From: Sandra Chapman
Sent: 03 April 2024 09:51
To: Kaleem Janjua
Subject: RE: -24/00168/FUL - 3 Rectory Row

Unfortunately at the request of the Planning Team Manager I still need a further amendment and some additional information prior to the validation of your application.

EXISTING SIDE ELEVATION 2

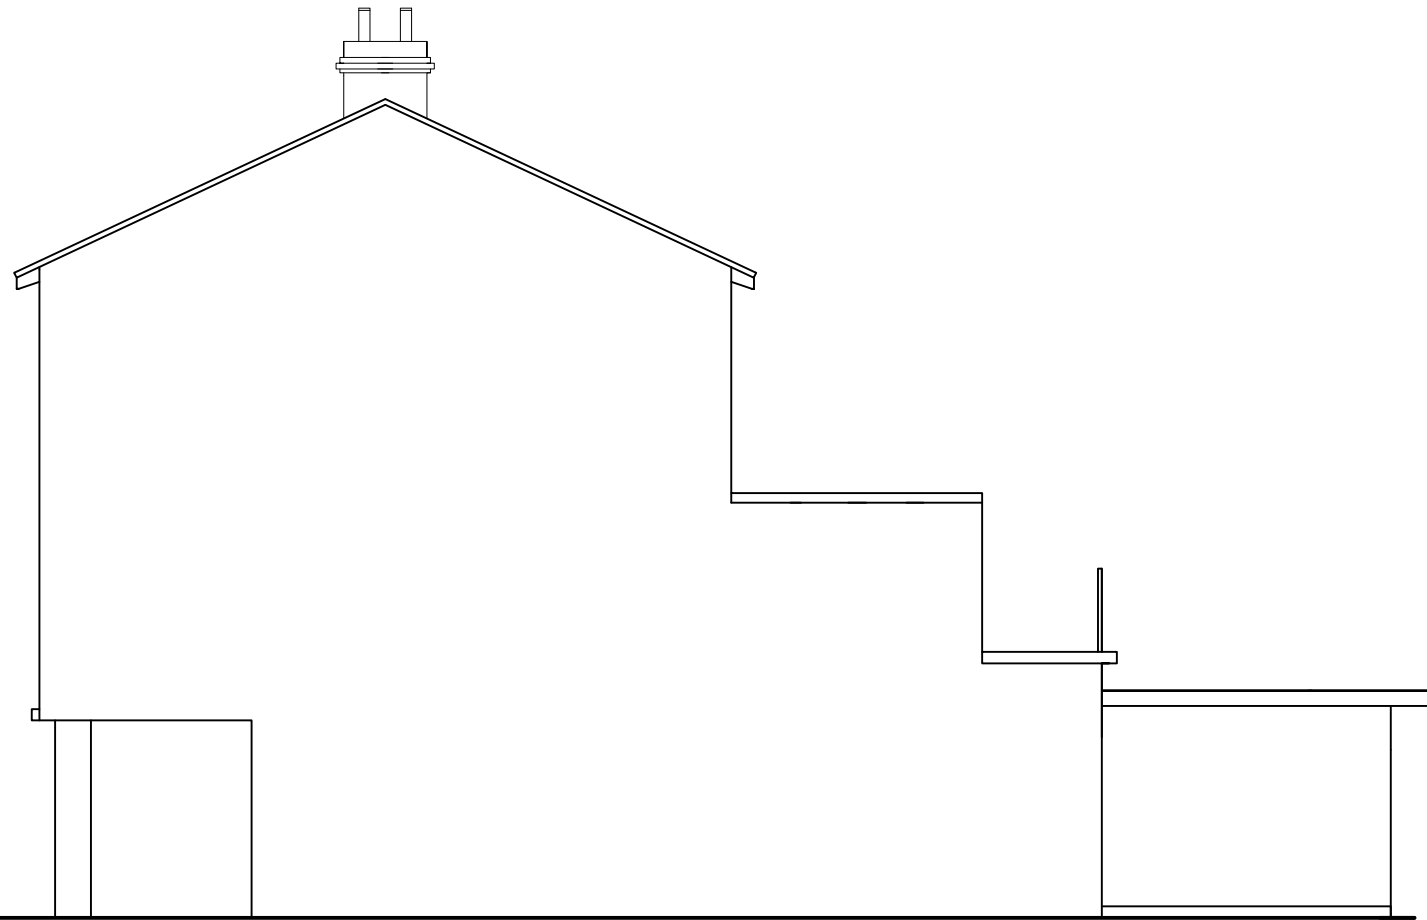
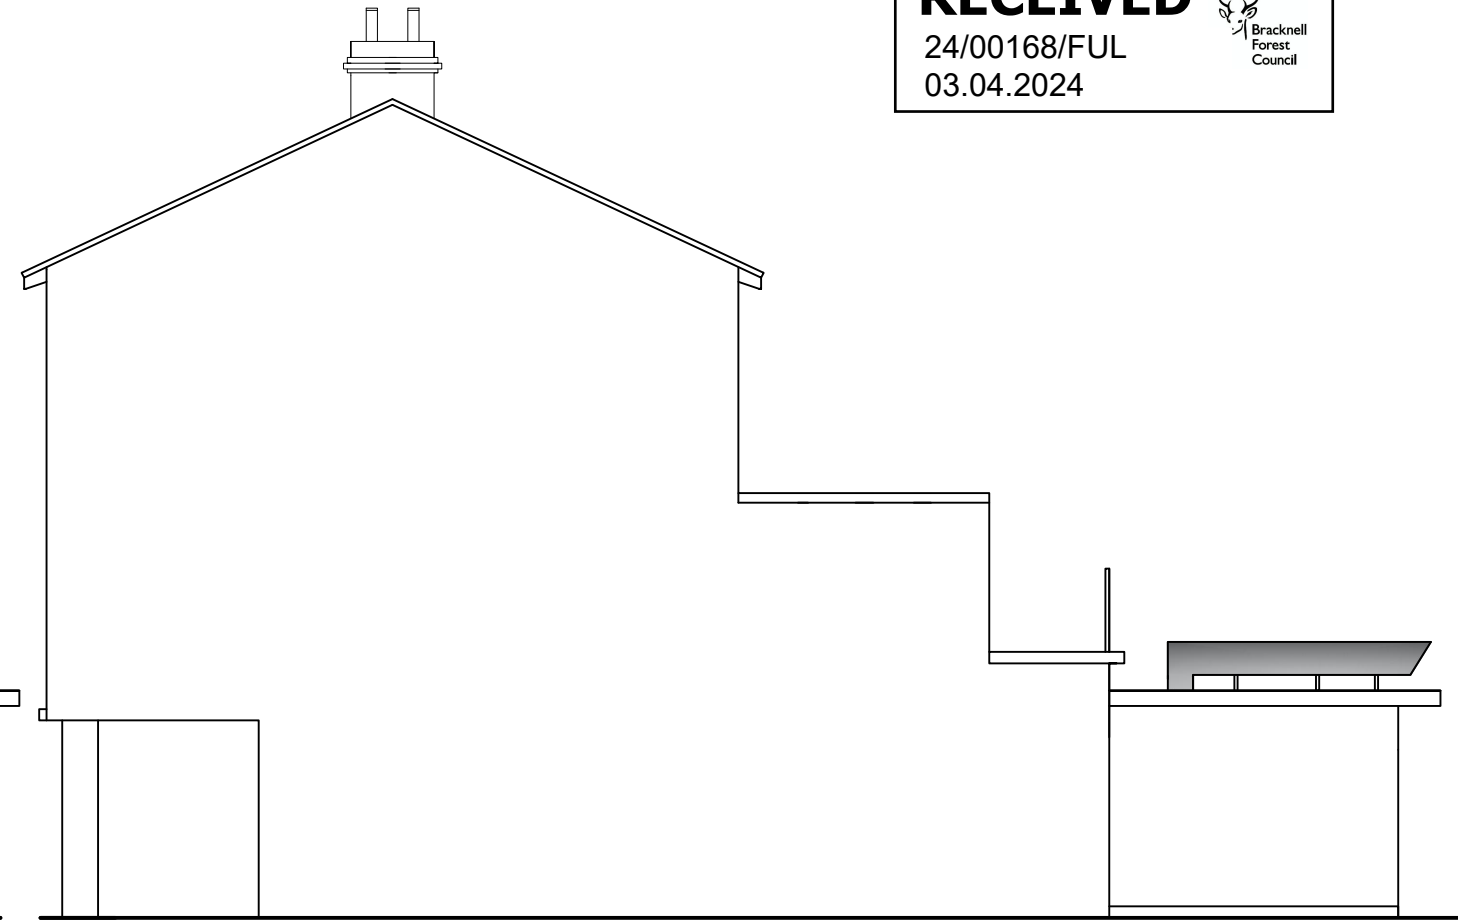
Please provide existing and proposed alternate side elevations showing the extractor/flue.
